PROJECT NAME: **The Sasse Ridge Plat (LP-11-00002)**

Request to Set a Closed Record Meeting to consider the Hearing Examiner's recommendation for Sasse Ridge Plat (LP-11-00002) for March 19, 2013.

Re: LP-11-00002, Sasse Ridge Plat

IN THE MATTER OF)	RECOMMENDED FINDINGS OF
)	FACT, CONCLUSIONS OF
LP-11-00002)	LAW, DECISION AND
Sasse Ridge Plat)	CONDITIONS OF APPROVAL

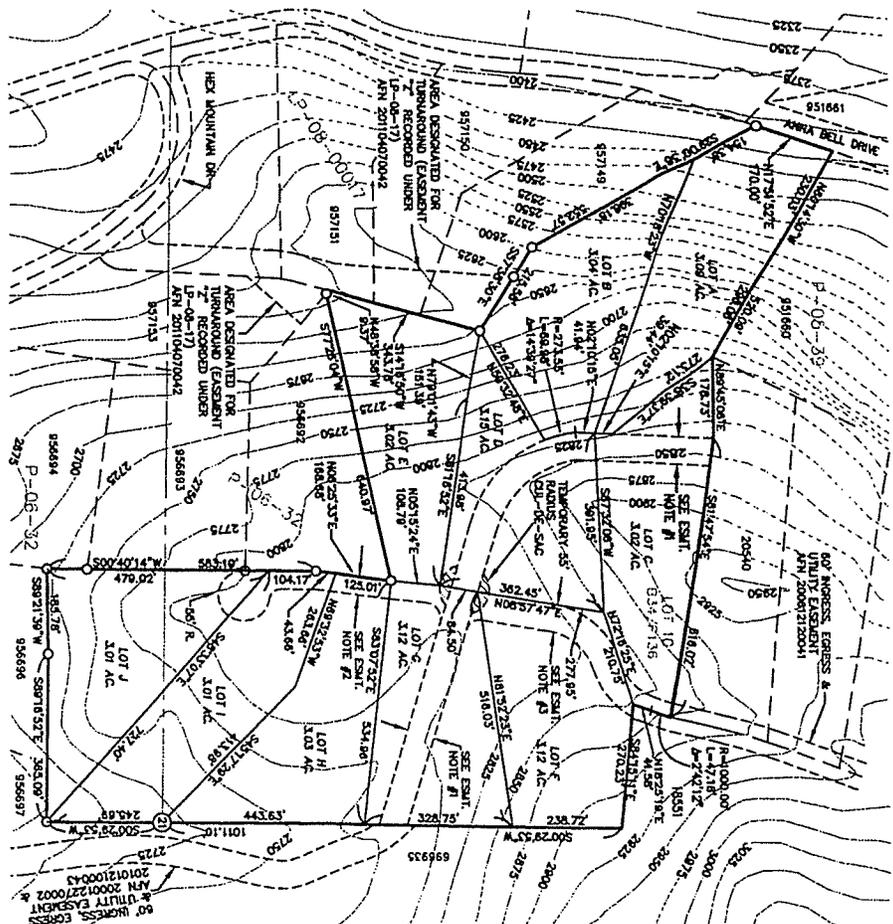
11. This proposal is not consistent with the Kittitas County Zoning Code 17.30.055 Yard Requirements – Zones Adjacent to Commercial Forest Zone. The preliminary plat map does not show the required 200-foot buffer for properties bordering or adjacent to the commercial forest zone. The minimum lot size is 3 acres. The lots in this proposal range in size from 3.01 ac. to 3.12 ac. (Staff report)
